Whalley Parish Council

PLANNING APPLICATIONS

3/2007/0951 – Proposal: Two storey side extension with two conservatory extensions to rear – Re-submission

Location: 1 The Grove Whalley BB7 9RN

PROPOSED PLANS AND ELEVATIONS

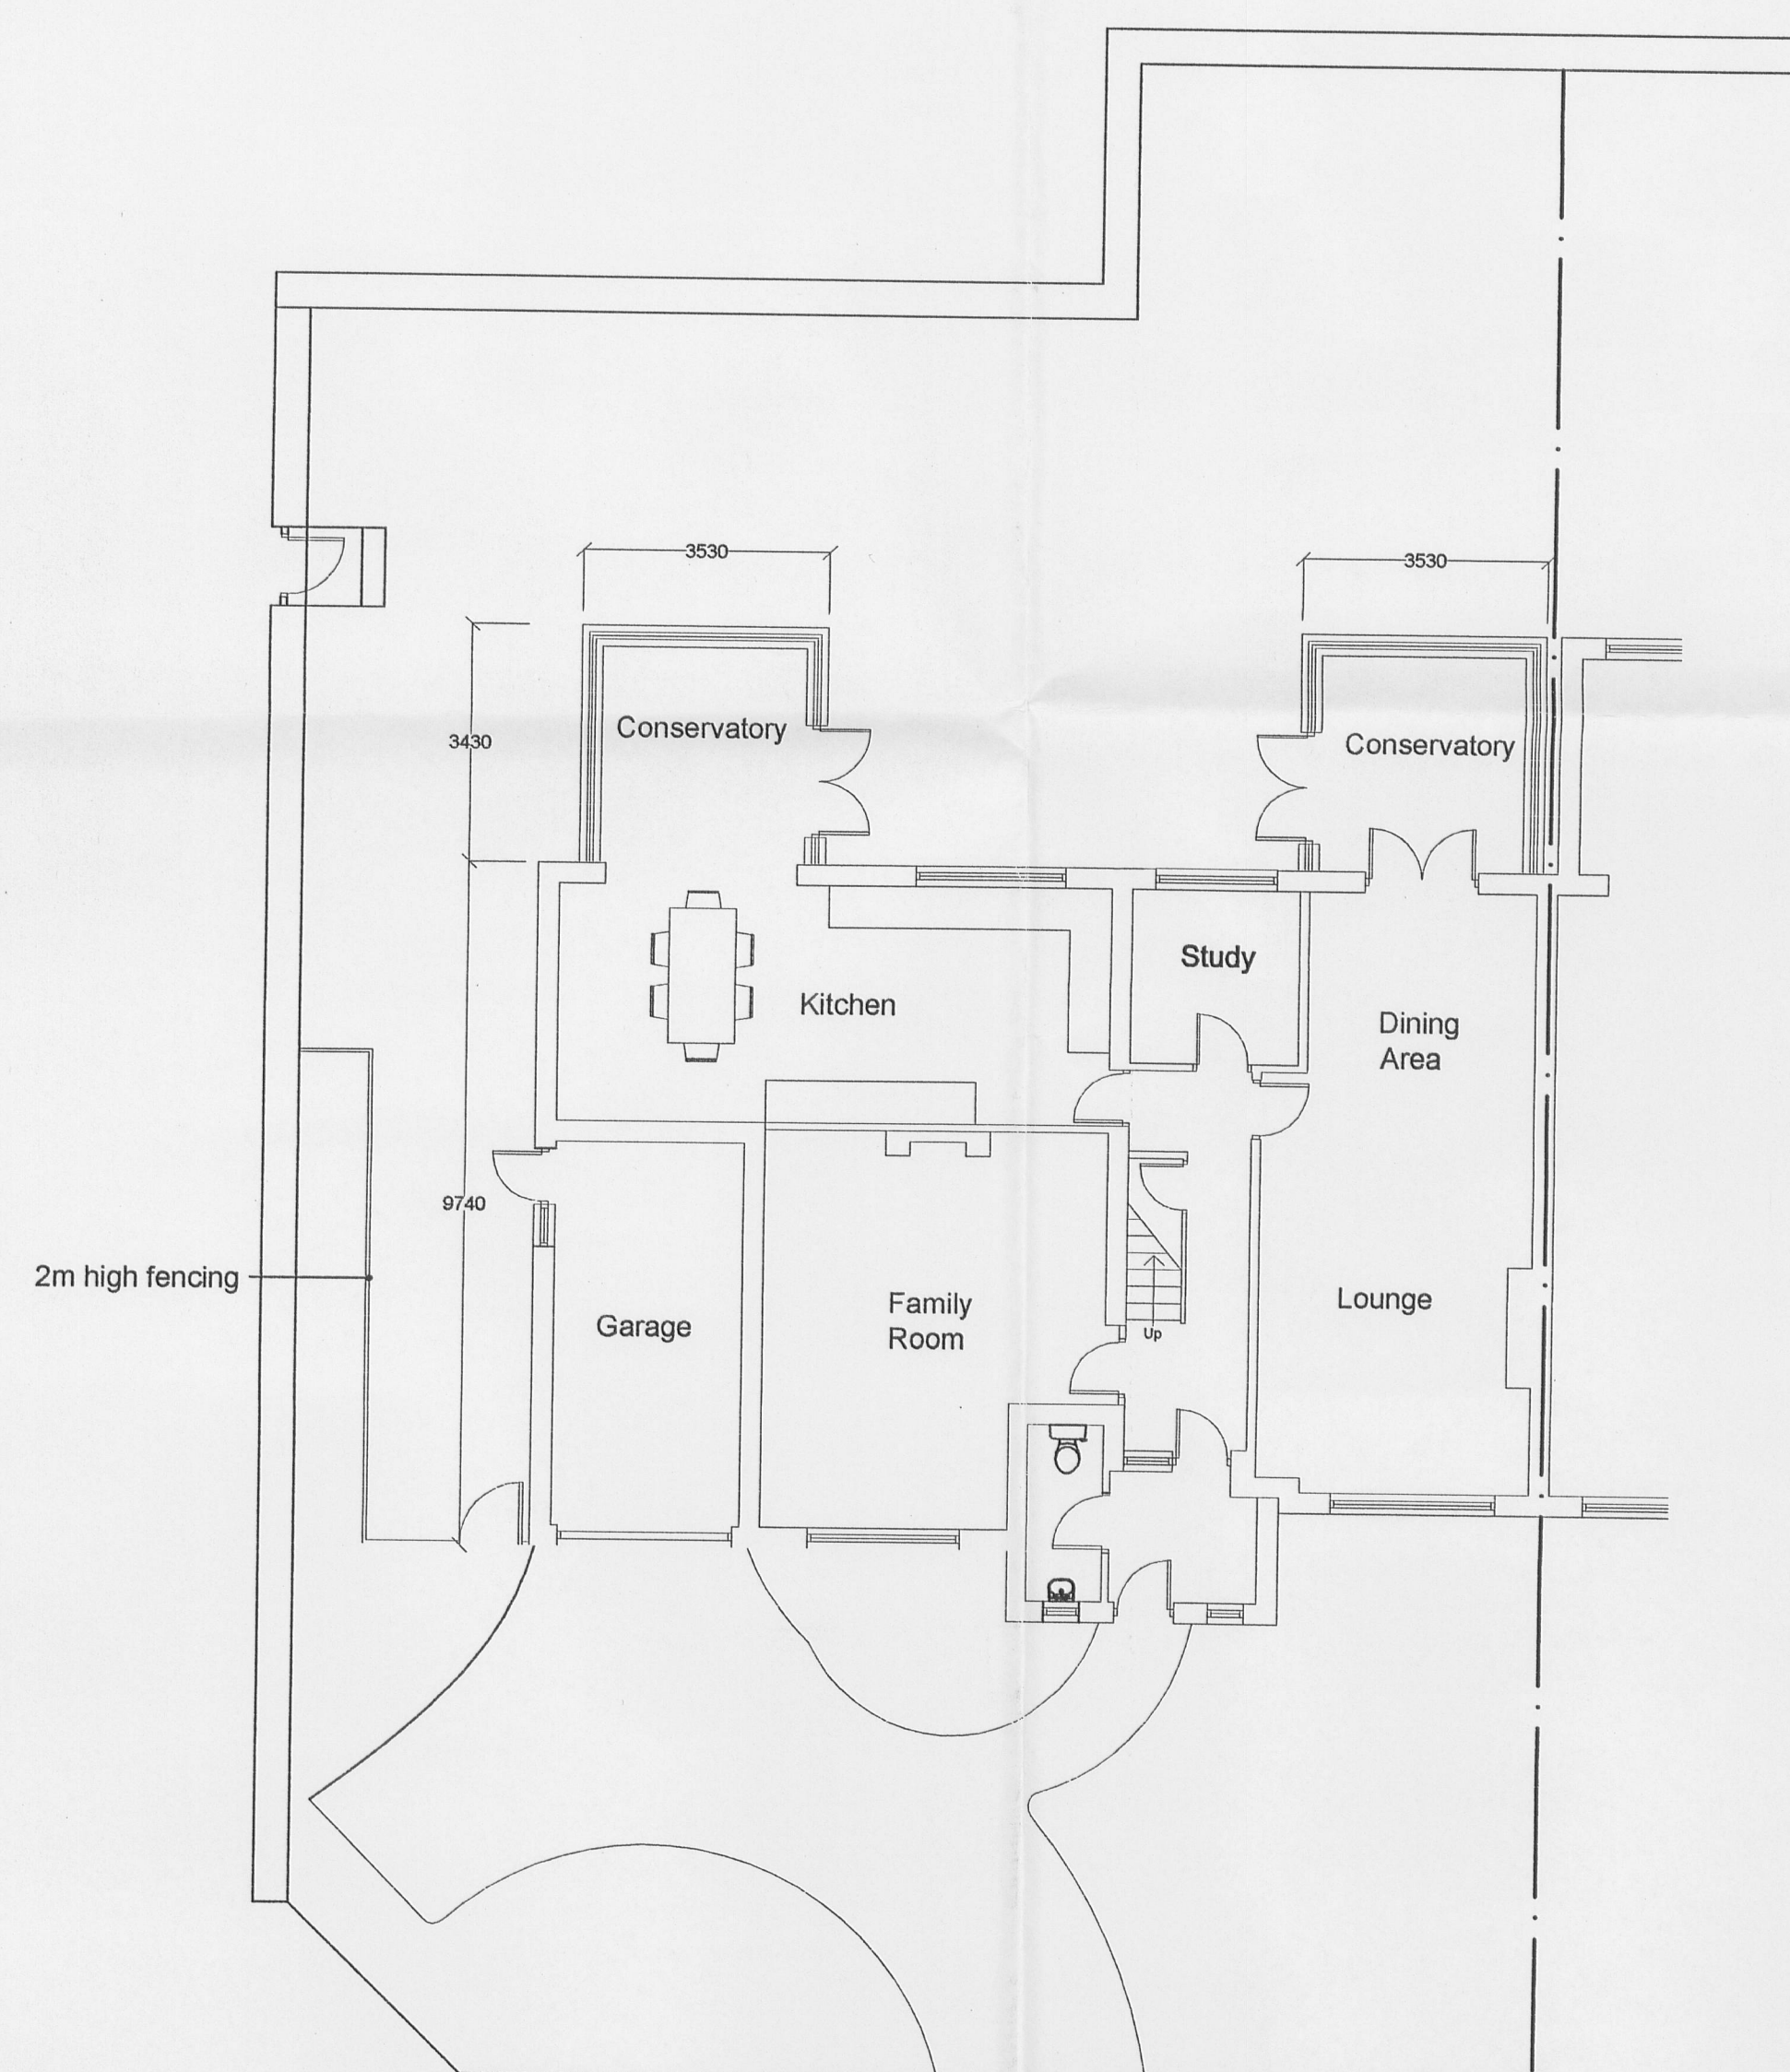
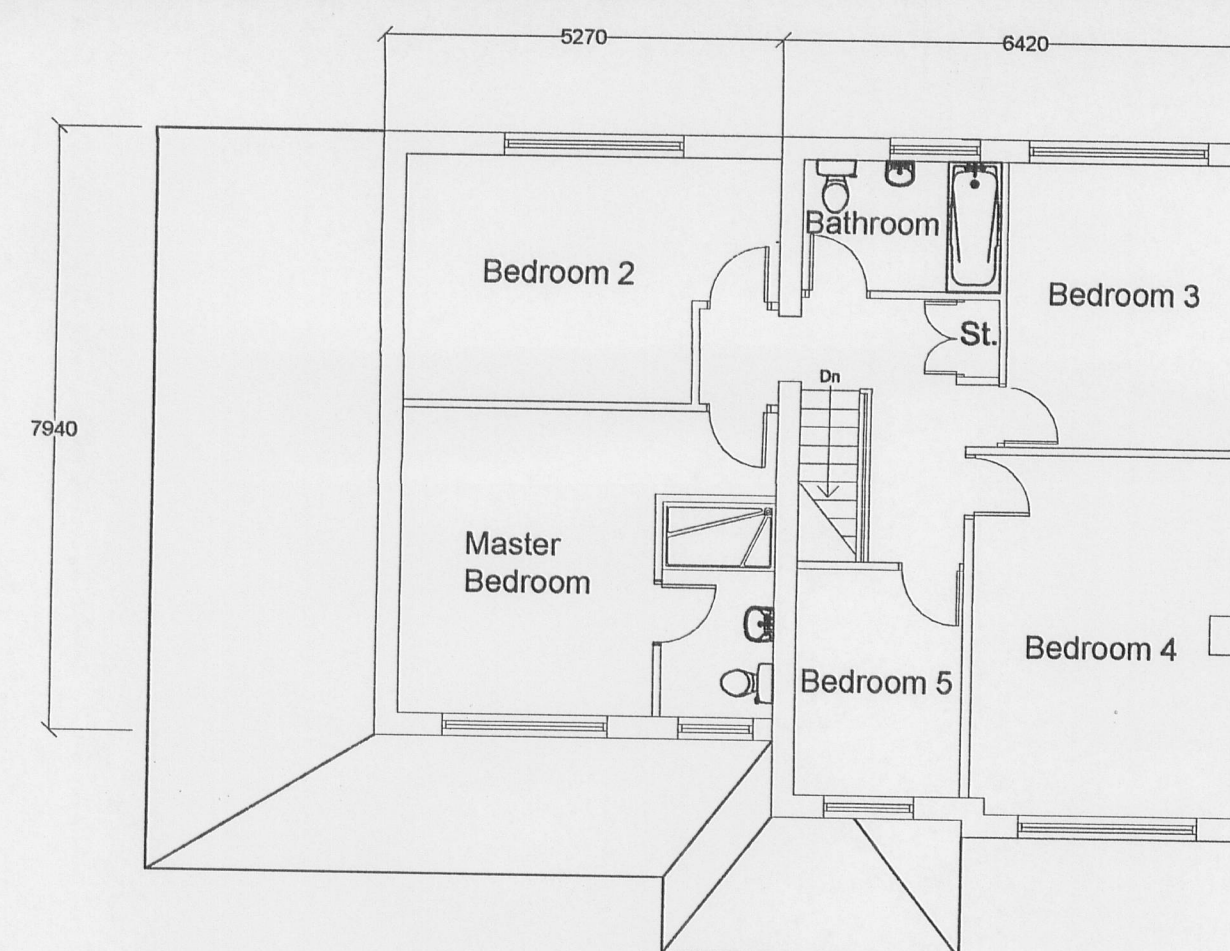
No Observations. However concern expressed that the proposed extension is still too large
